Our ref: NO/2013/105143/01-L01
Your ref: 3/2013/0229
Date: 23 May 2013

**RESERVED MATTERS APPLICATION (FOLLOWING THE OUTLINE APPROVAL OF
3/2011/0482P) FOR THE APPEARANCE, LANDSCAPING, LAYOUT AND SCALE
FOR 18 DWELLINGS AND ASSOCIATED WORKS - DISCHARGE OF CONDITIONS
10 & 11
LONGSIGHT ROAD, COPSTER GREEN, BLACKBURN**

We have reviewed the details as submitted and we are unable to recommend the discharge of Conditions 10 and 11 at this time.

**ROAD AND MAIN
DRAINAGE LAYOUT**

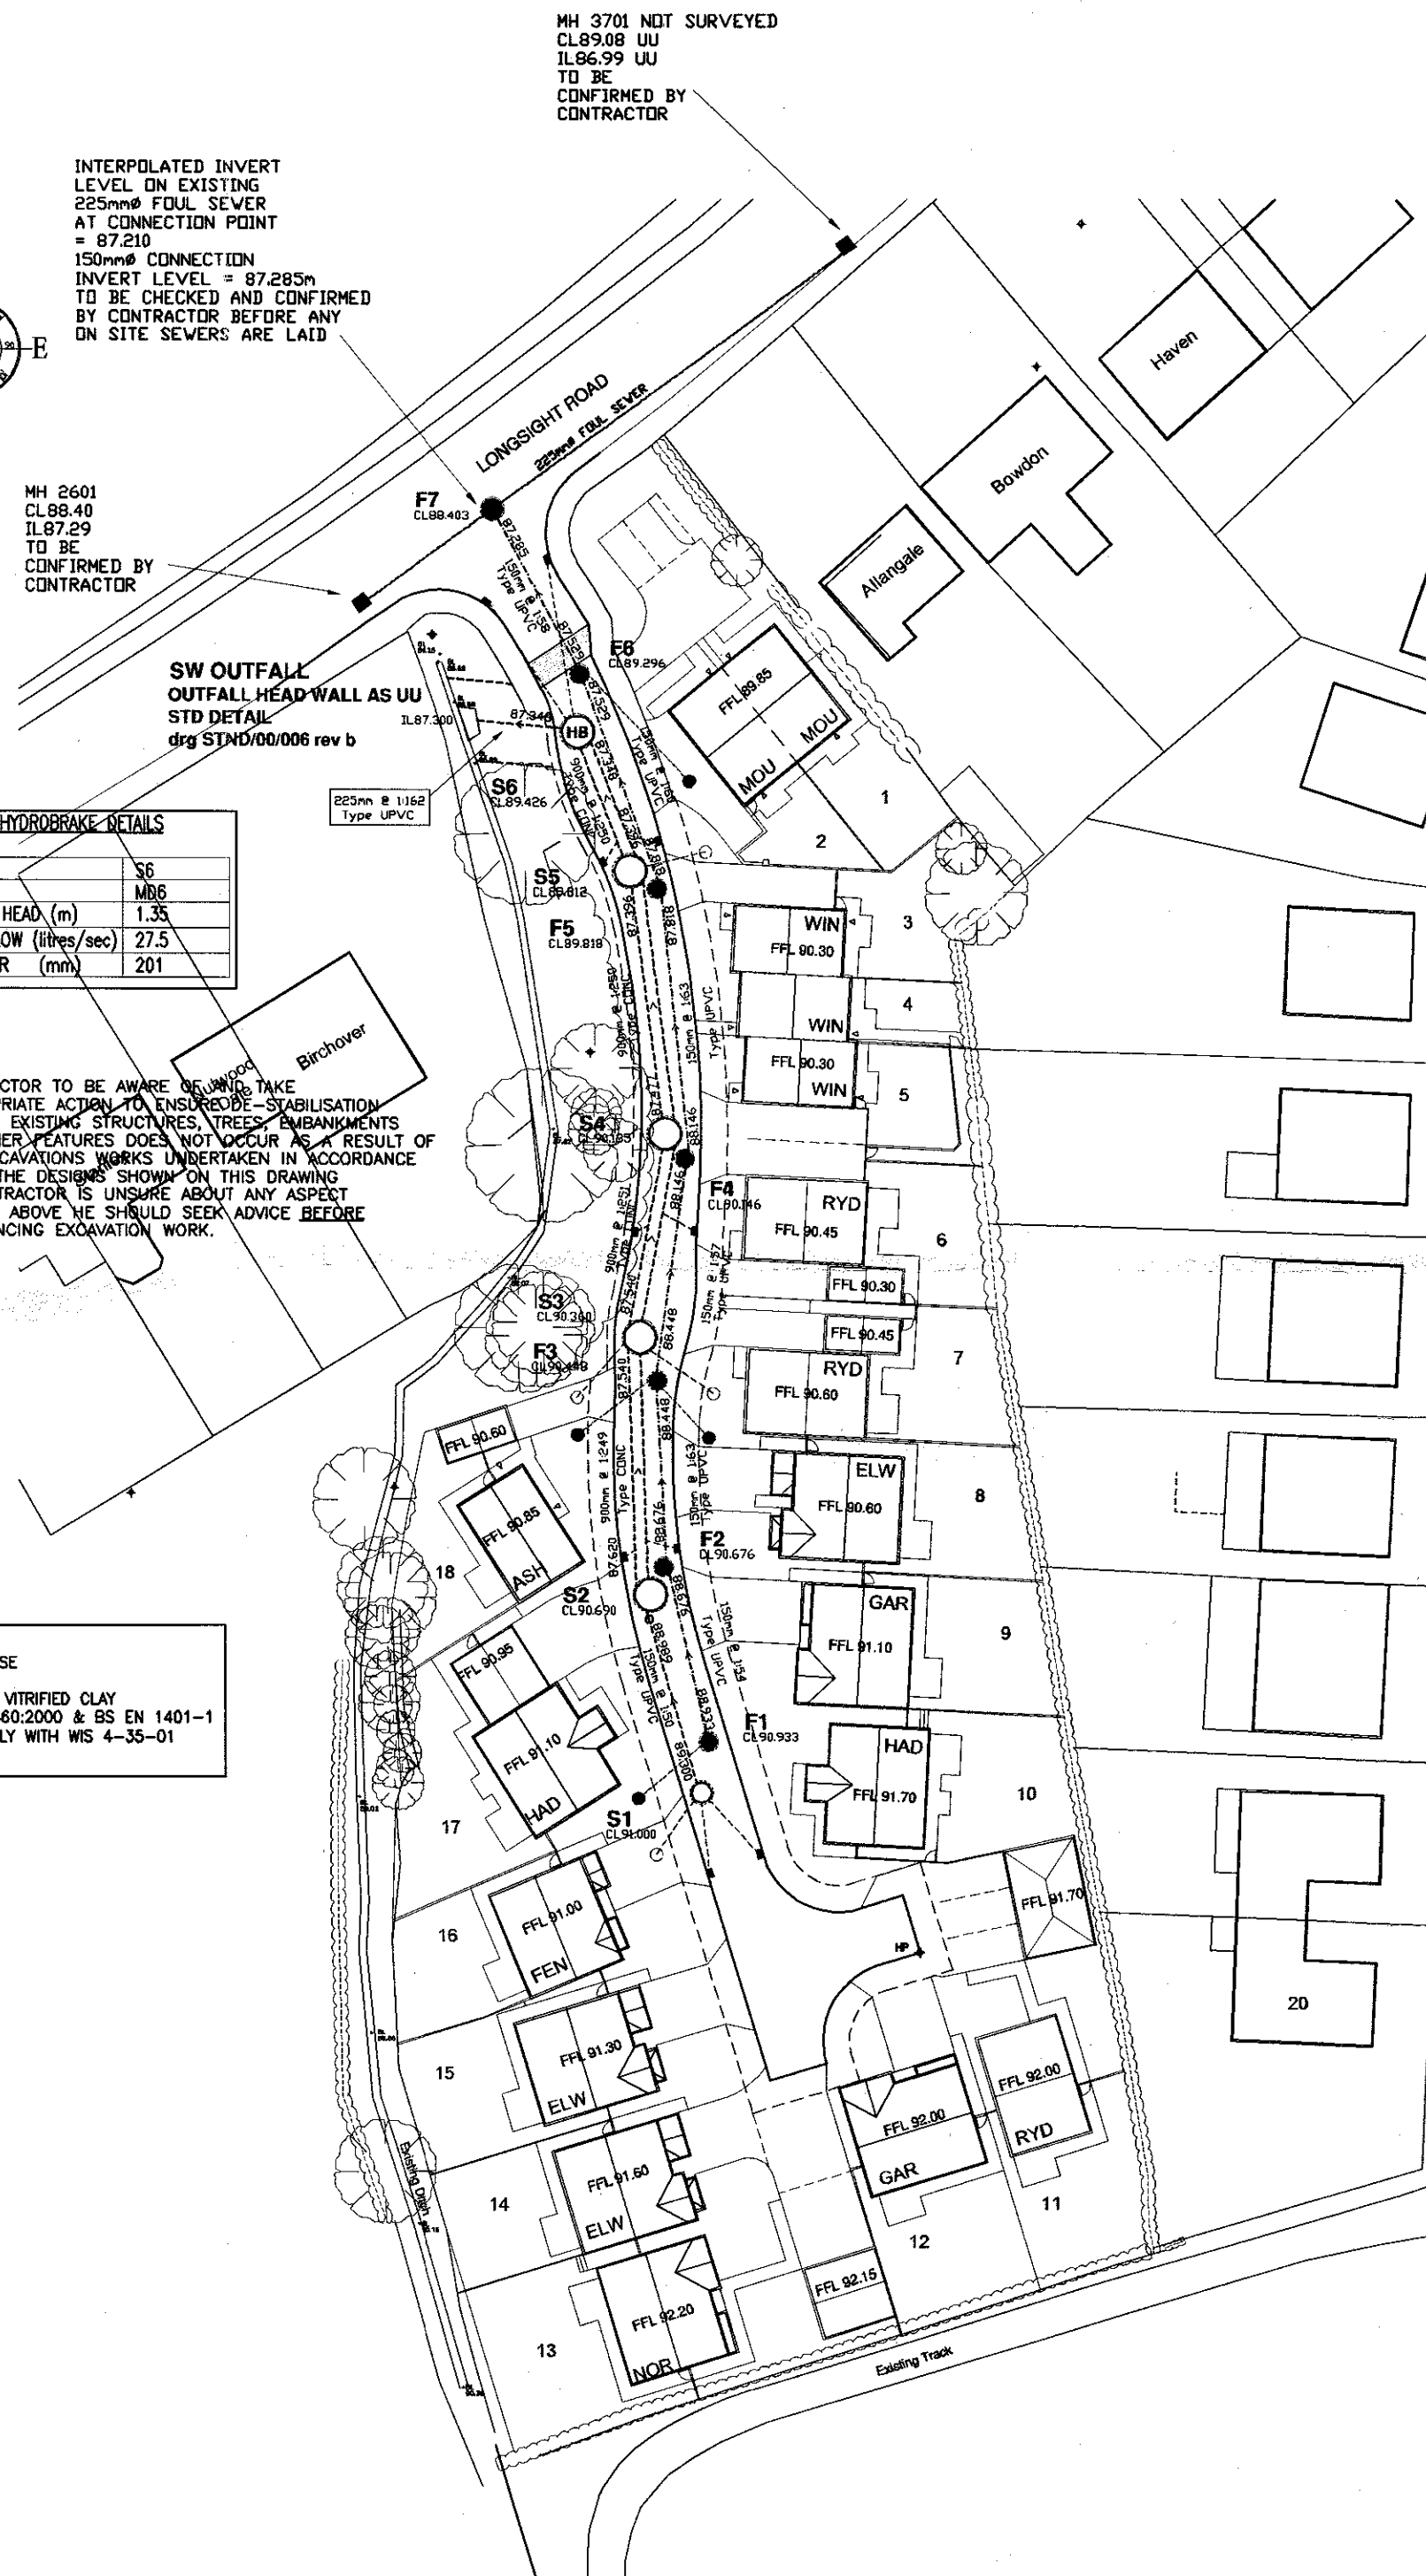
We note that surface water is to be discharge to the adjacent watercourse, but no details of the existing or proposed run-off rates or details of any surface water attenuation measures that may be required have been submitted.
